Application for a Non-Material Amendment Following a Grant of Planning Permission Town and Country Planning Act 1990 (as amended)

Erection of second floor extension to the Powell building, erection of lift and demolition of temporary structure

2024/62/91055/E

Drawing No.  
HWK01-E3C-21-ELZ-DR-A-001

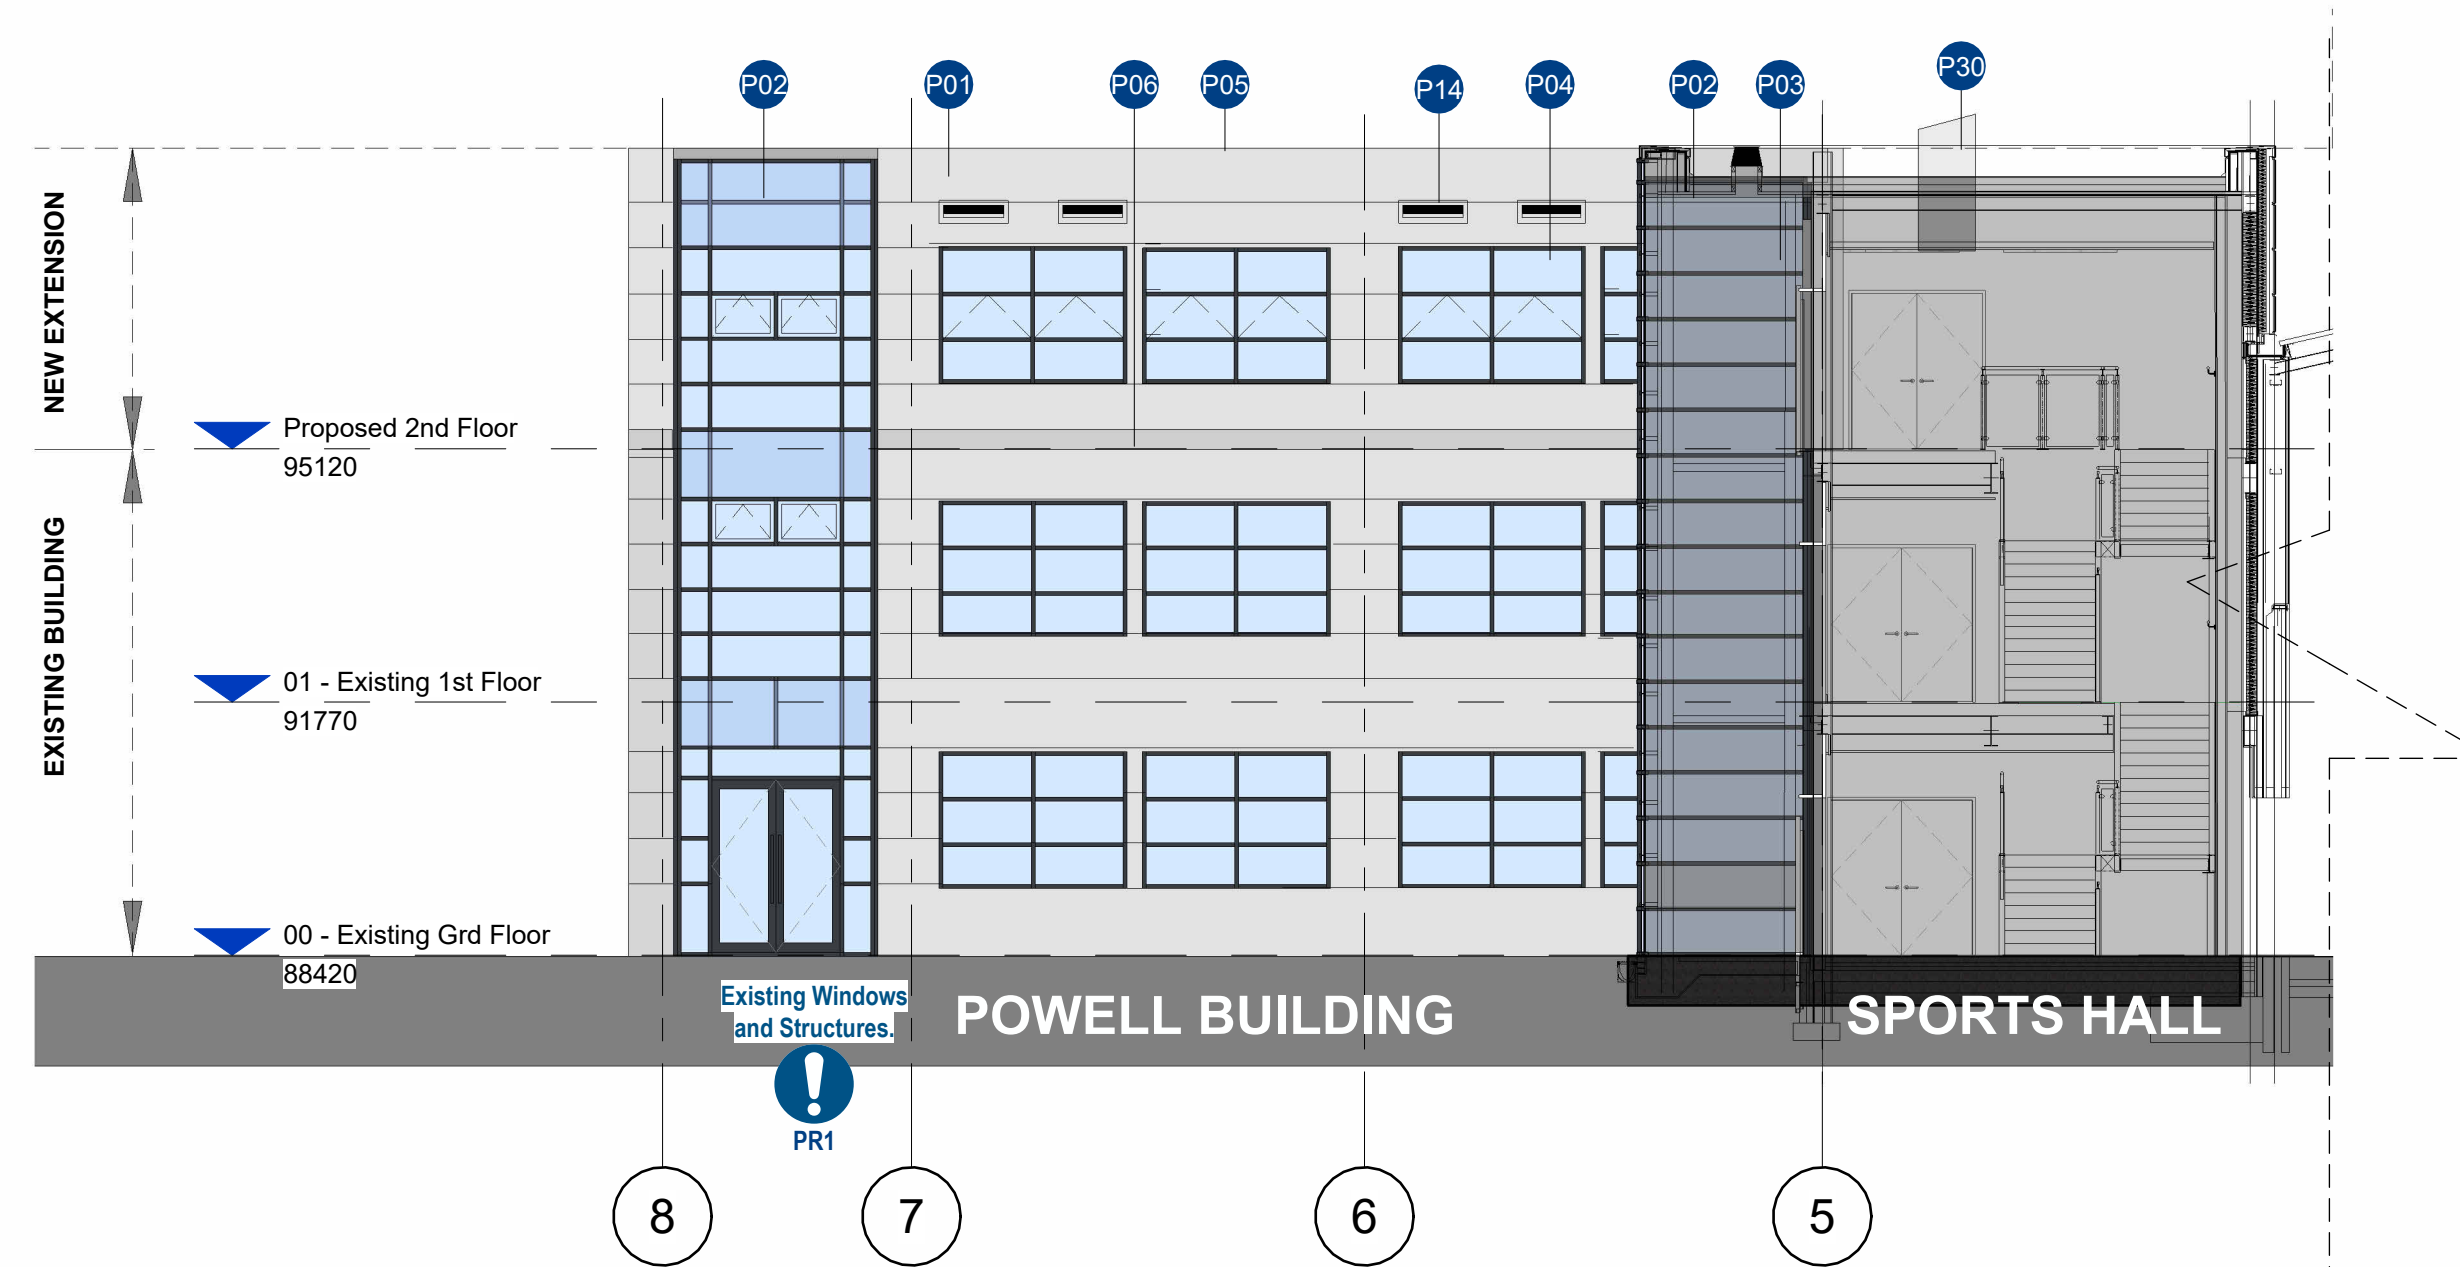
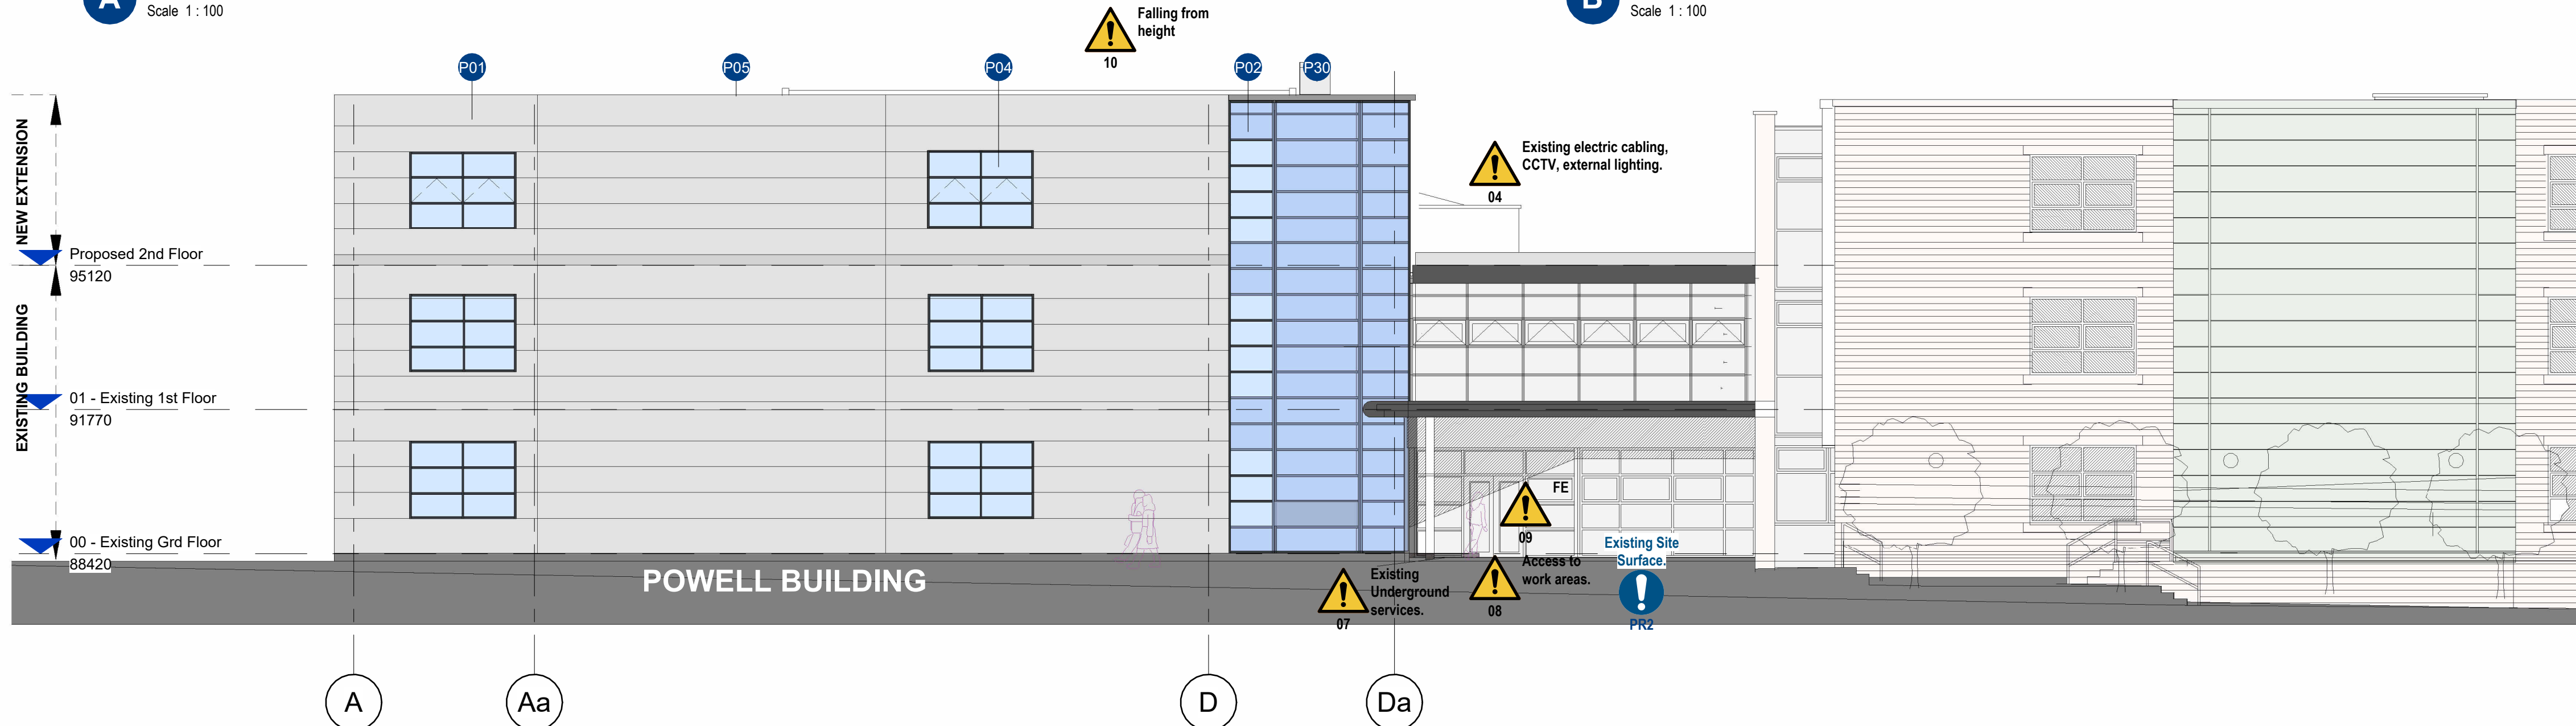
The New second-floor extension cladding colour is to be changed to Silver Grey to match the existing.

The change in colour for the new second-floor extension cladding is intended to better integrate with the building's existing aesthetic, providing a more cohesive appearance.

HWK01-E3C-21-ELZ-DR-A-001-A3-P02

HWK01-E3C-21-ELZ-DR-A-001-A3-P06
